Subject: Land at Woodgate Nurseries, Lidsey Road, Woodgate AL/89/24/OUT

We refer to your planning consultation response for Land at Woodgate Nurseries, Lidsey Road, Woodgate AL/89/24/OUT.

When checking the impermeable areas I did come across an error on my part. The measured impermeable area for AREA3 is actually 0.22Ha (NOT 0.6Ha). I had carried out an earlier iteration during design with a bigger AREA3 and inadvertently put those figures into the document.

SURFACE WATER DRAINAGE STRATEGY AREAS 2&3

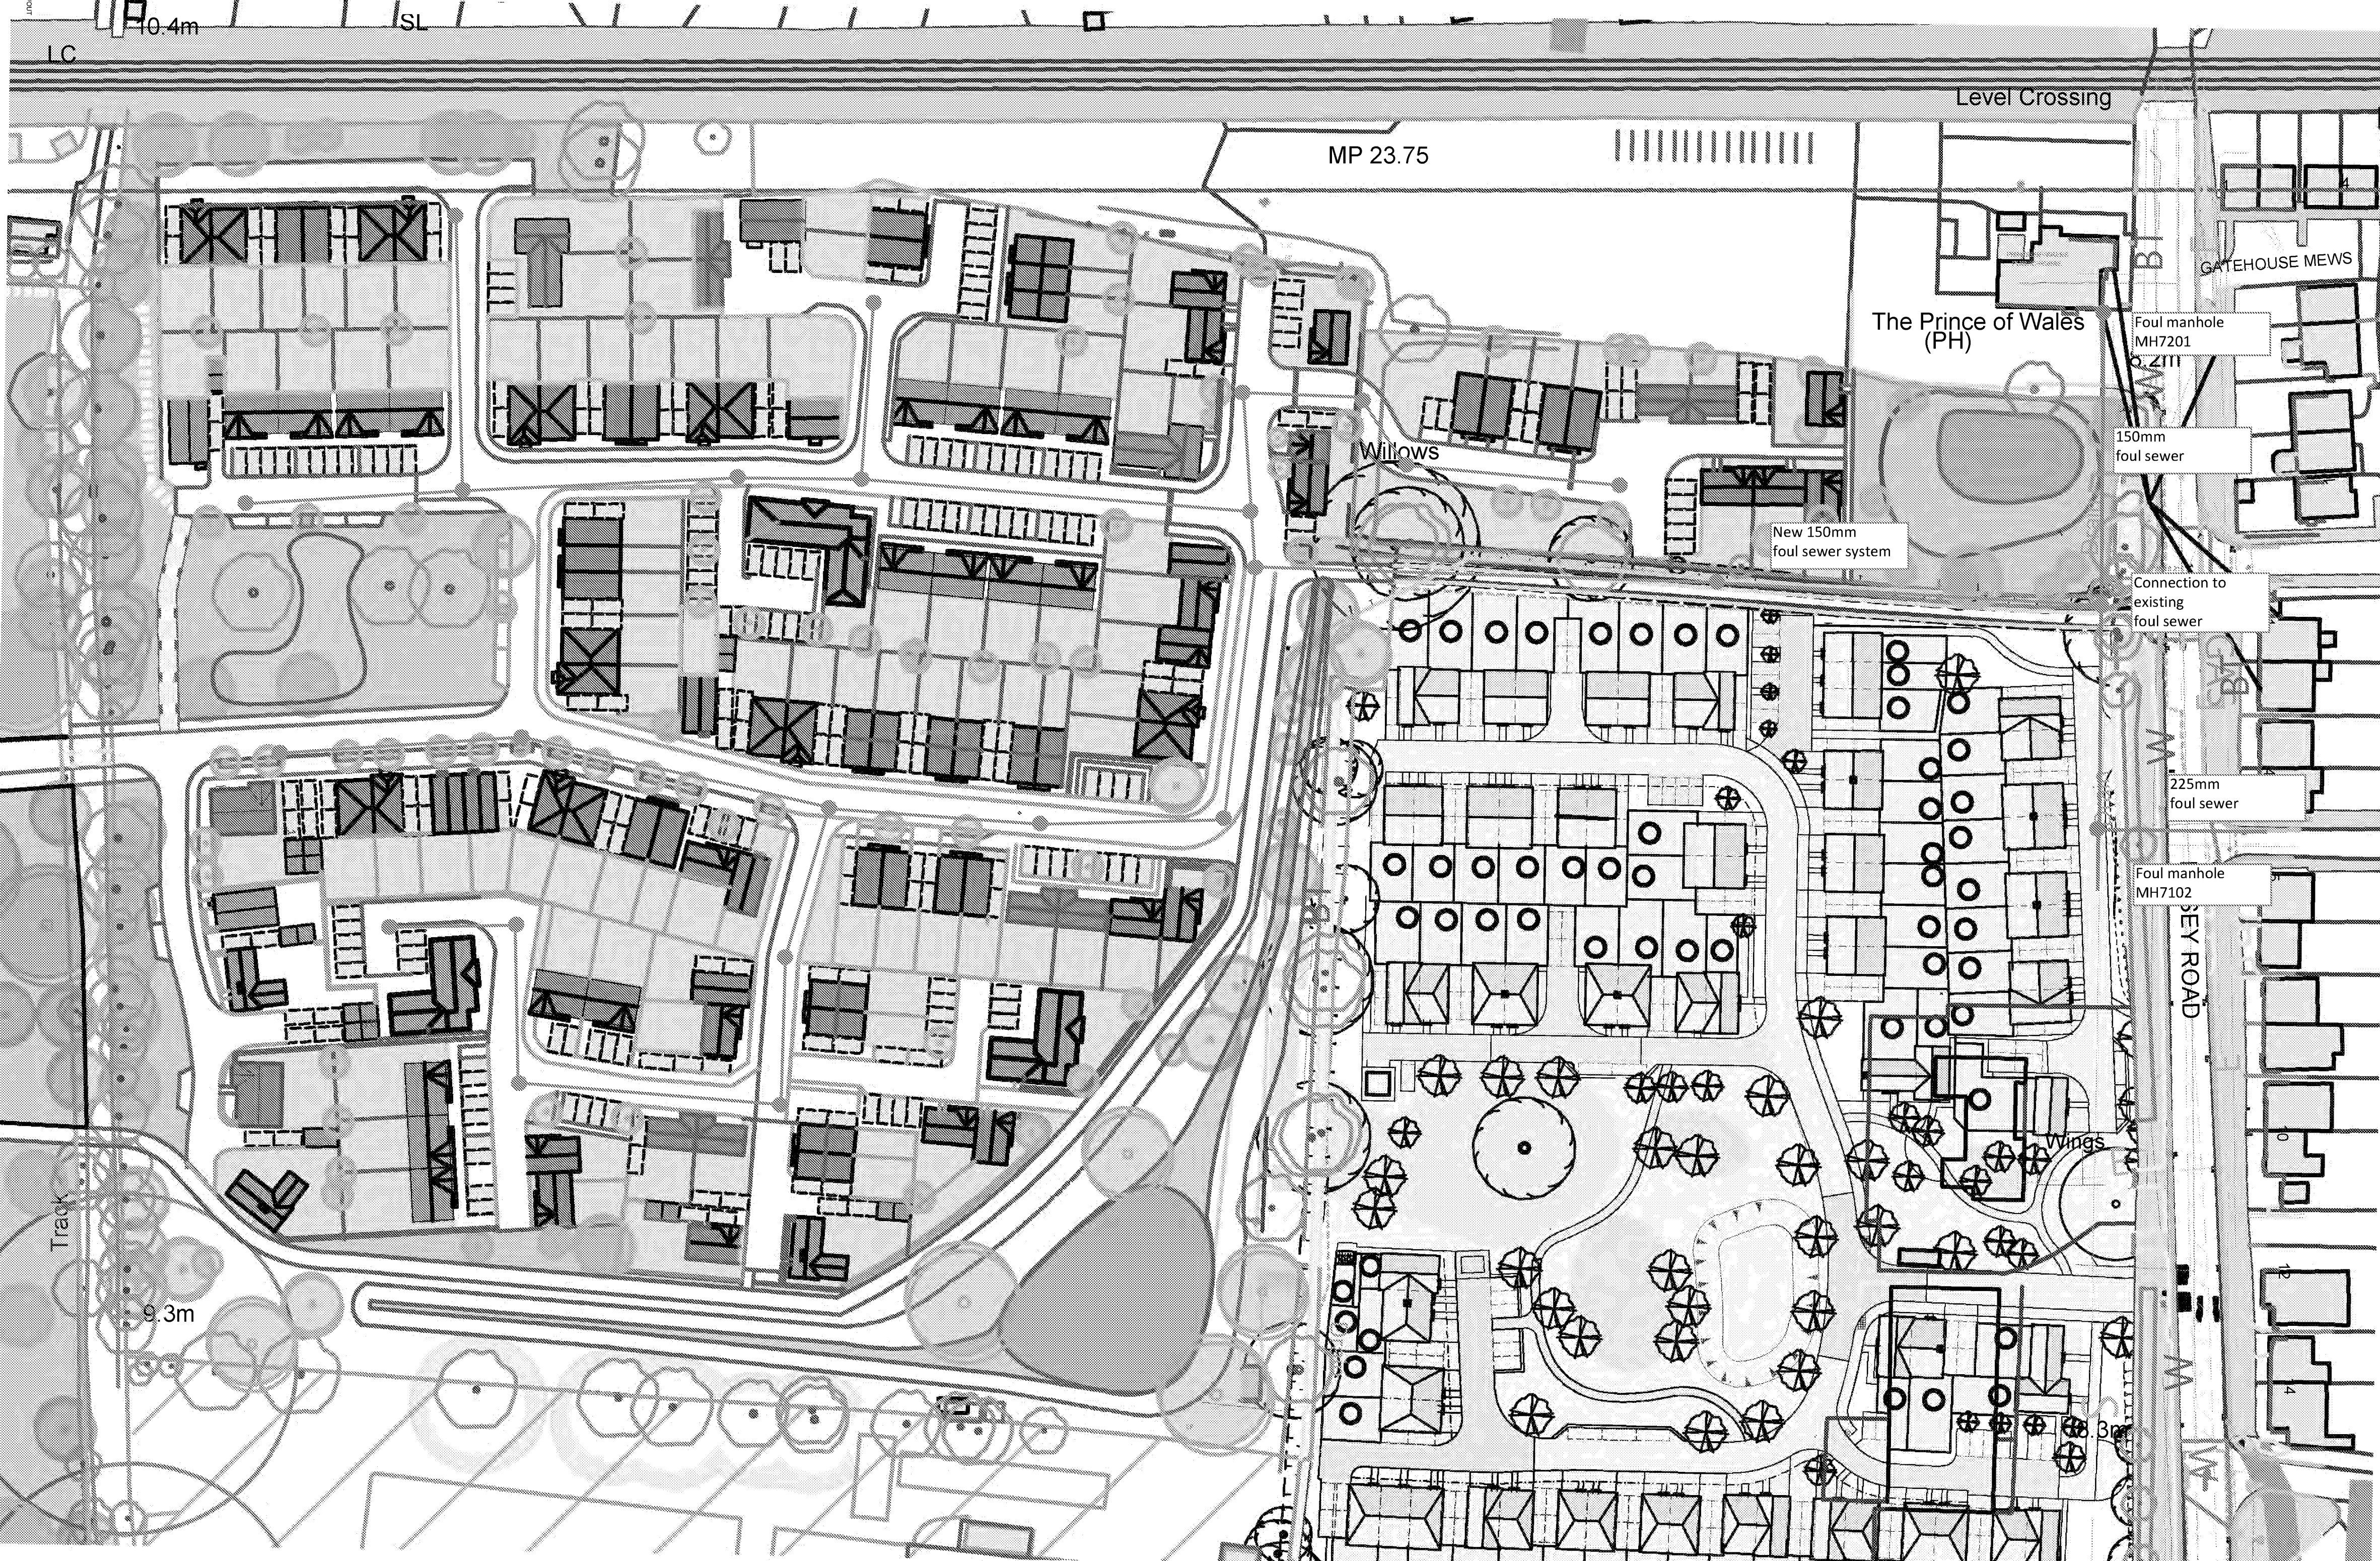
AREA 3

Roof area = 0.0736Ha

Paved area= 0.122Ha

Combined=0.1956Ha

Creep allowance=0.02Ha

Total = 0.2156Ha (0.22Ha)

The modelled impermeable area for AREA 3 in the FRA of 0.6Ha is in error. The measured area is 0.22 Ha.

This is now corrected and the FRA updated accordingly.
